From: Laura Gibbons
Sent: 20 June 2018 14:01
To: Anita Gardner
Subject: RE: R/85/18/DOC - Rustington Convalescent Home

The applicant hasn't exactly provided what I requested in terms of additional calculations, however after some further interrogation of the results and some additional calculations by me I am happy to recommend the condition is now discharged based on Revision G of the drainage strategy.

Hi Anita,
I have reviewed the information, and provided comments in red below.
My original comments were:

PLASTIC INSPECTION CHAMBER

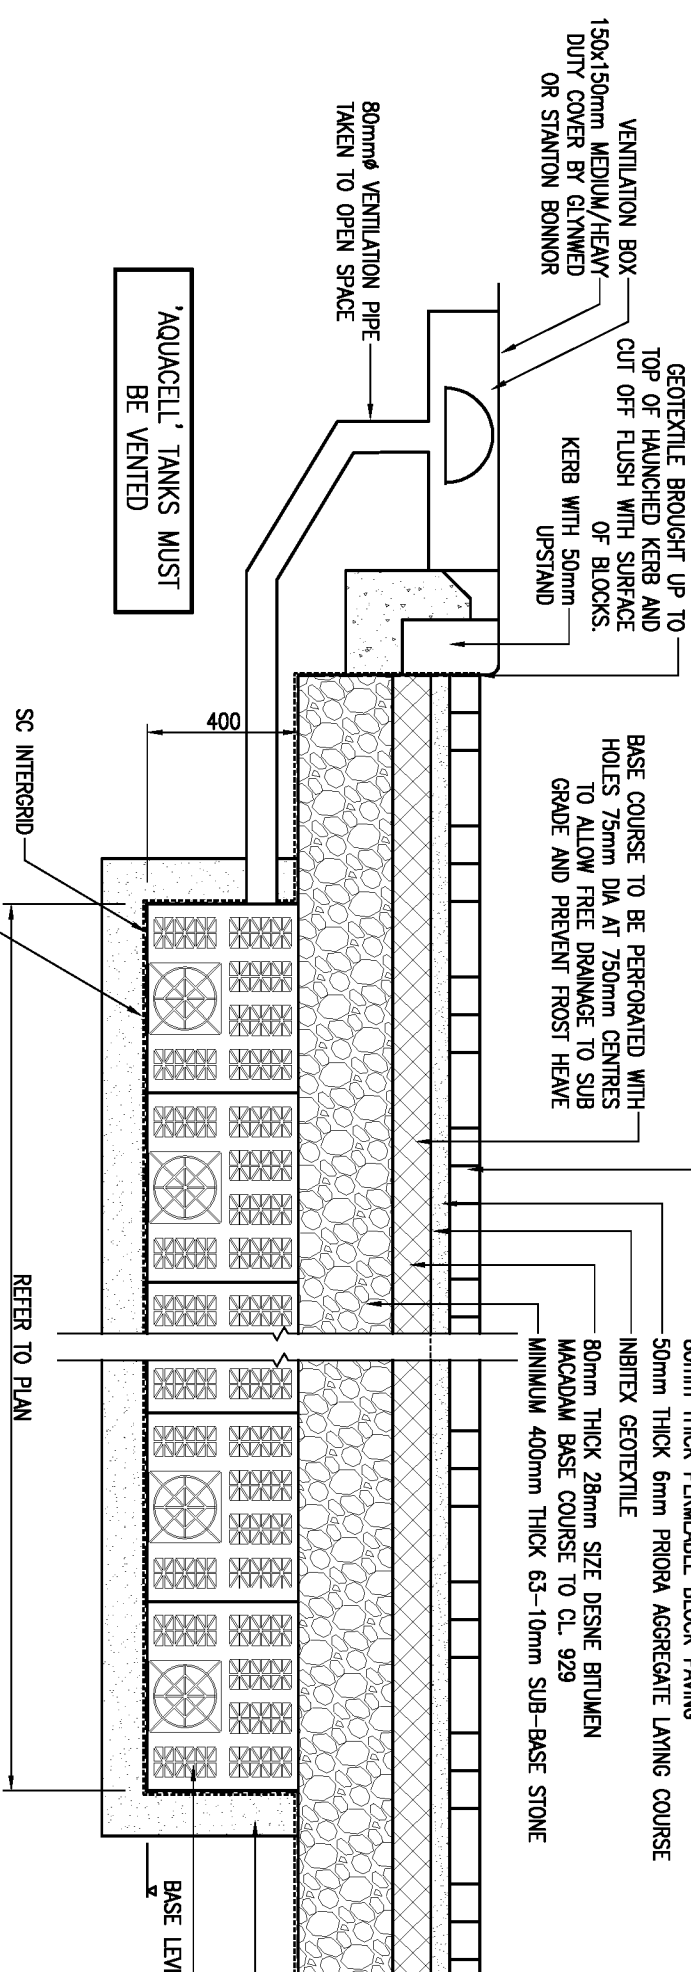
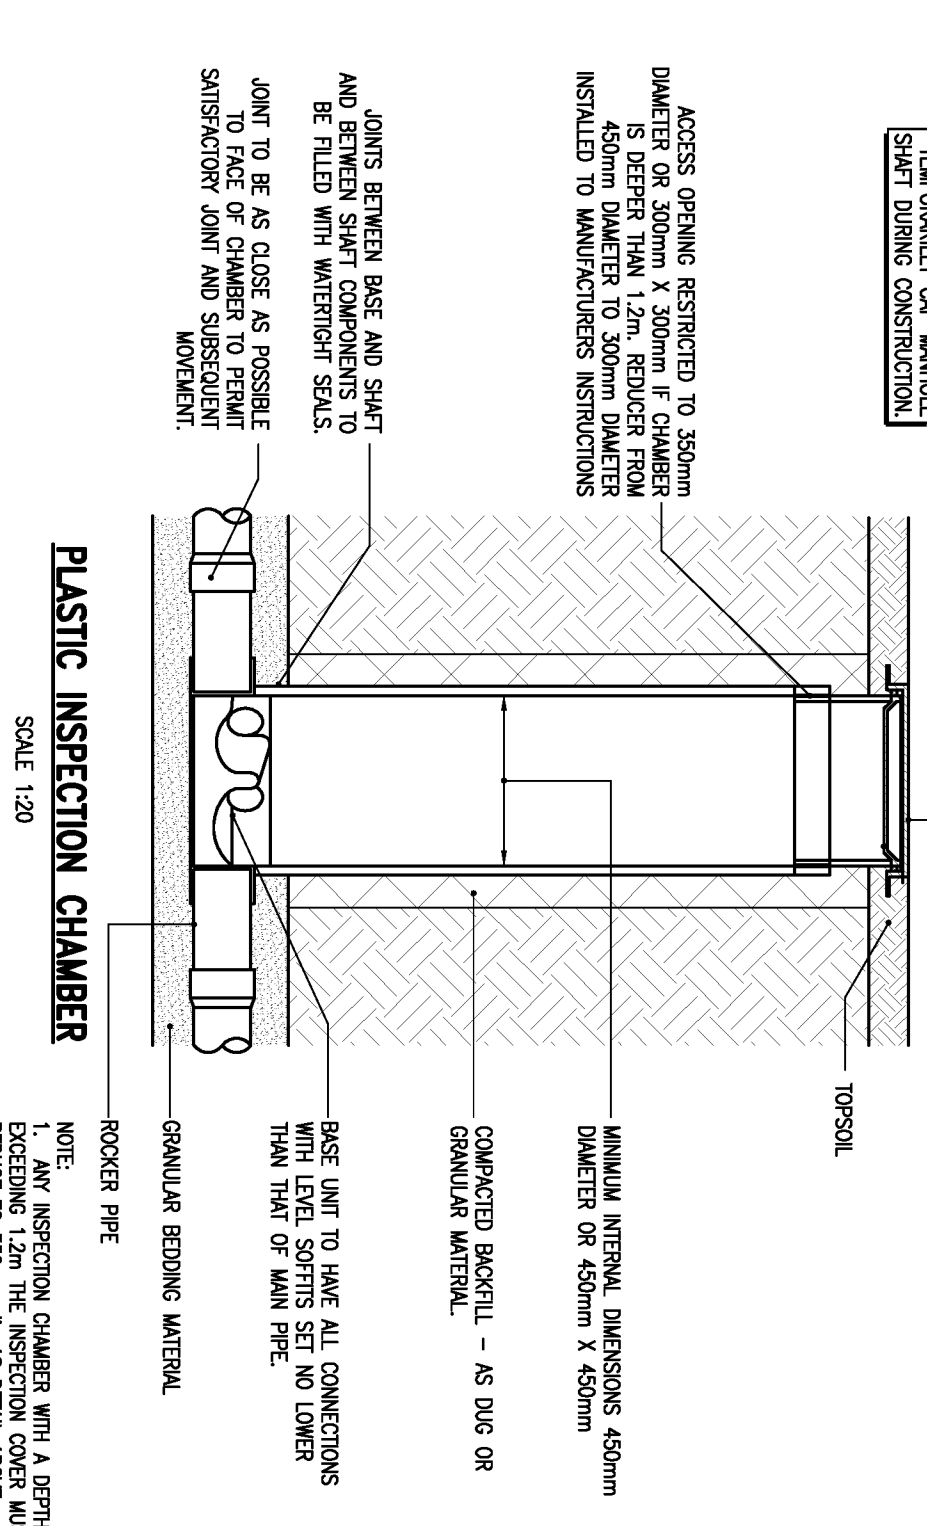
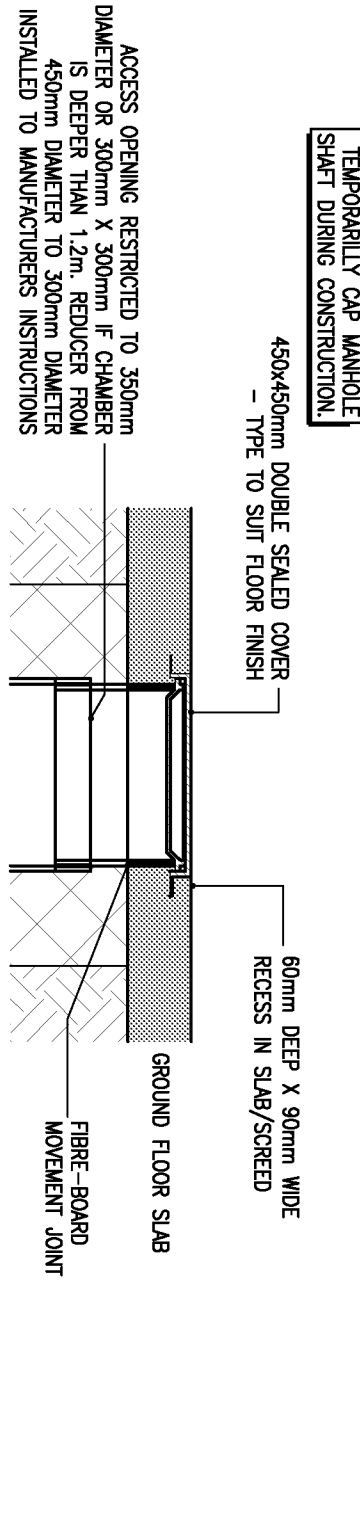
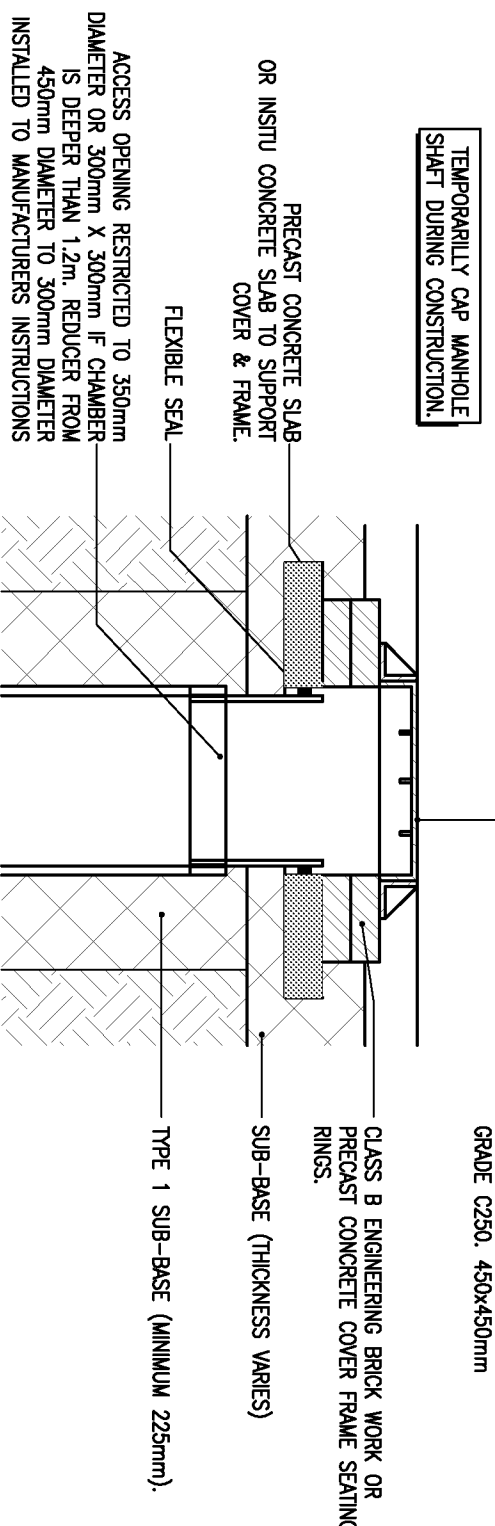
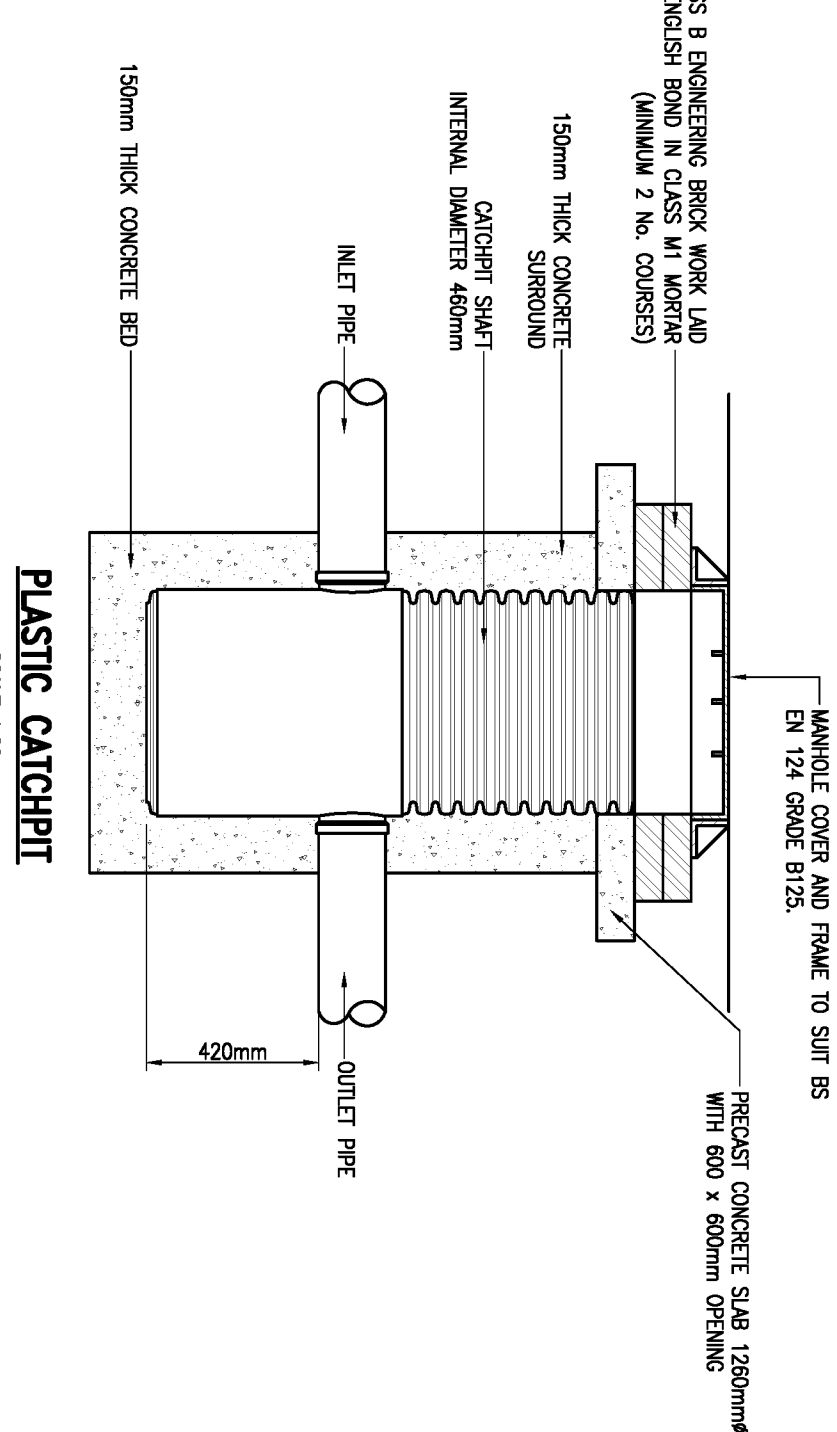
There is one catchpit missing on the drawing supplied (on the eastern soakaway of soakaway 1). Please can the drawing be revised to include this.

- o Pipes, labelled with invert levels, slopes and diameters. Okay.
 - o Catchpits/ manholes/ inspection chambers clearly labelled with cover types and dimensions specified. Please provide details of catchpits and cover types.

- o Exceedance flow routes. Okay.
6. Construction detail drawings of all drainage structures, including; manholes, catchpits, inspection chambers, soakaways, permeable paving. Please provide catchpit details.

Catchpits have been noted on the site plan on page 17 of the attached report, noted as IC (CP) and details added to the Drainage Construction Details drawing on page 18 of the attached report.

Catchpit details have been added to the Drainage Construction Details drawing on page 18 of the attached report.
